From: Plater, Roger - Oxfordshire County Council <Roger.Plater@Oxfordshire.gov.uk>
Sent: 06 January 2023 15:32
To: Simon Tucker
Cc: White, Joy - Oxfordshire County Council; Andy Bateson
Subject: 22-01488-OUT OS Parcel 5616 adj Huscote Farm and M40 J11

This email is a follow-up to the Transport comments contained within the second OCC response dated 30 November 2022 and to confirm the issues identified by our Traffic Signals officers in relation to the LinSig analysis, as discussed earlier.

Based upon the ORDNANCE SURVEY MAPS with the permission of THE CONTROLLER OF HER MAJESTY'S STATIONERY OFFICE,  
 © Crown Copyright AL 100030412  
 © David Tucker Associates

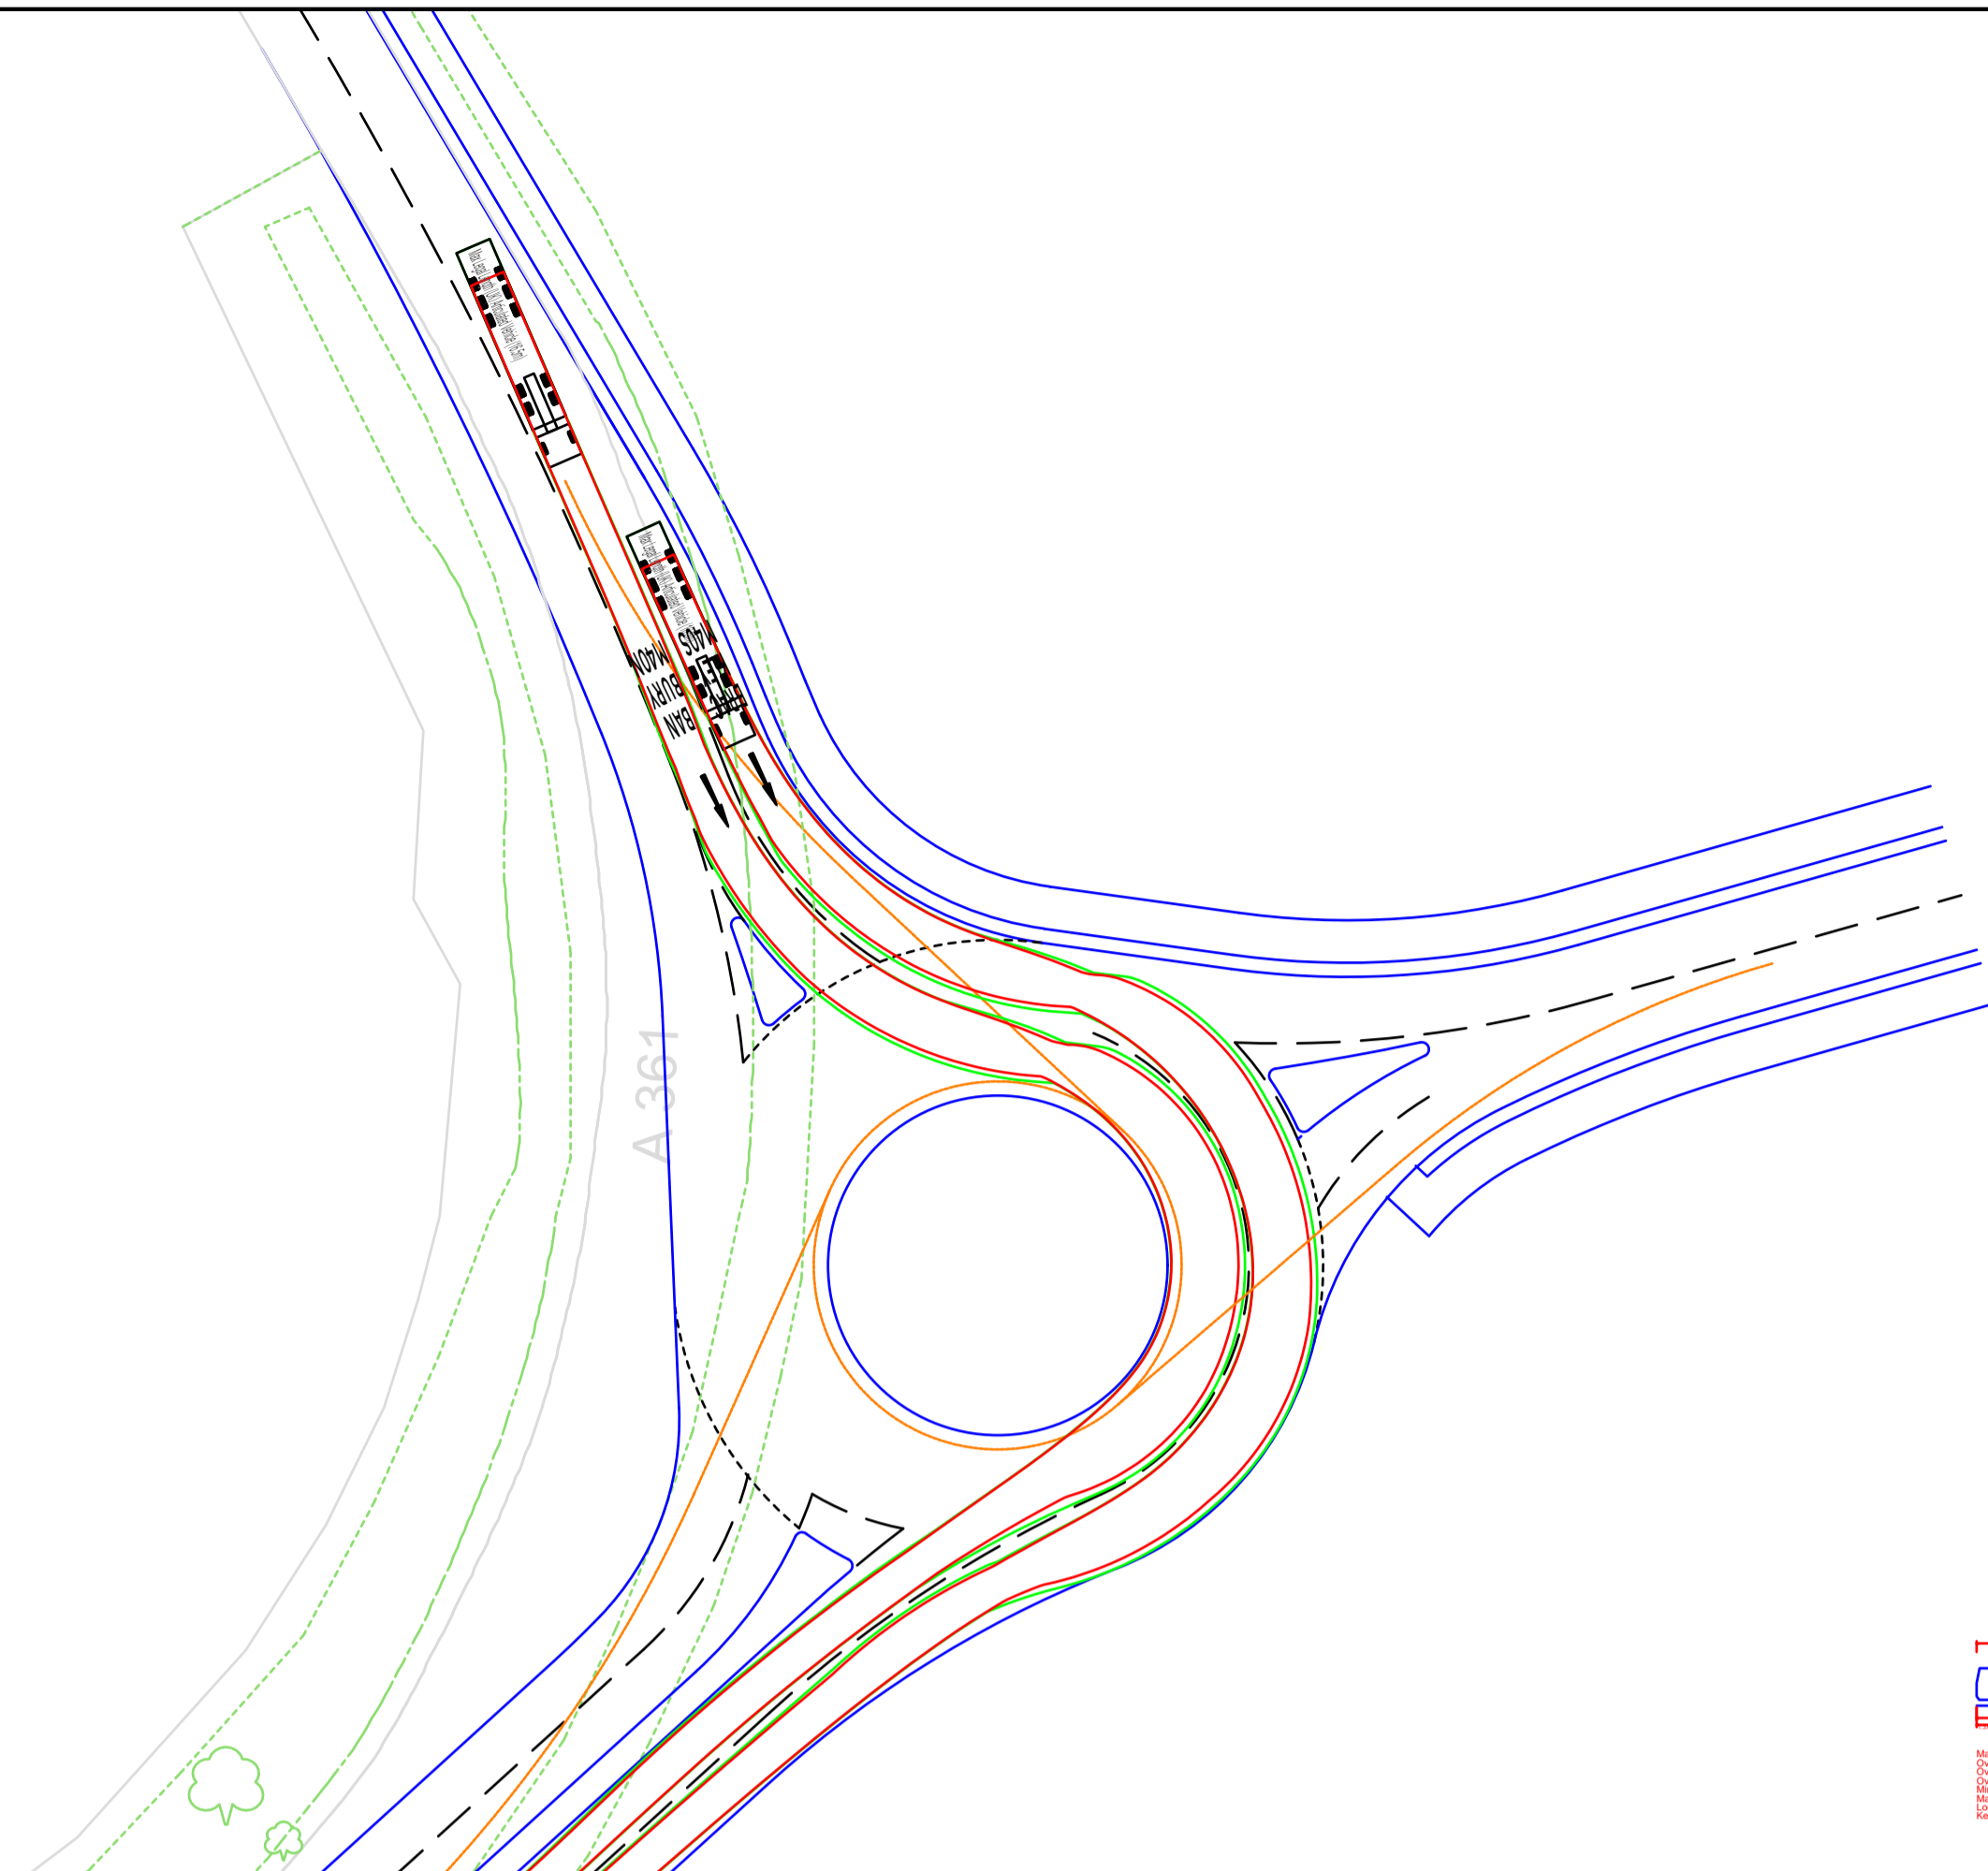
1. The layout drawing no. 23459-06-02-GA Rev. A, titled "M40 Junction 11 Gyratory" and contained in the TA Addendum, shows two lanes at the stop line where the A361 meets the roundabout. However, the LinSig model is not consistent with this as it includes a third lane for straight on and left turn to the A422. This third lane has a capacity of 10 PCUs; approximately equating to 57.5m in length. Inclusion of a third lane would be within the site boundary but will have a further implication to the embankment supporting the carriageway and potentially to the drainage as there is a pond nearby. Details of the extended embankment, including cross-sections, are required as the embankment will have to be adopted.

2. The LinSig analysis includes a flare to a third lane on the M40 southern overbridge. This is to accommodate seven PCUs so should be approximately 40m long. The layout drawing, however, shows the lane to be only approximately 17m long. Furthermore, the drawing notes "bridge unaffected". This is disputed as the proposed kerbline is outside of the current structure. Additional width will have to be constructed to incorporate a footway, utilities/infrastructure and the barrier. It is considered that the proposal would require significant works to the overbridge and the embankment.

3. The LinSig analysis contains changes to lane usage and links at various locations around the junction. These are at the M40 northbound off-slip, M40 southbound off-slip and the circulatory between the A422 Hennef Way and the M40 northbound on-slip (as well as the changes resulting from points 1 and 2 above).

The layout drawing needs to show all the proposed road markings, including arrows and destinations, and lane widths, and HGV swept paths of all movements alongside one another should be provided, to allow a review of the paths through the junction and confirm lane capacity.

DTA will review and modify the layout drawing as necessary so that it is entirely consistent with the proposals analysed using LinSig. It is also recognised that the proposed layout changes will need to be incorporated into the VISSIM analysis model when that work progresses.
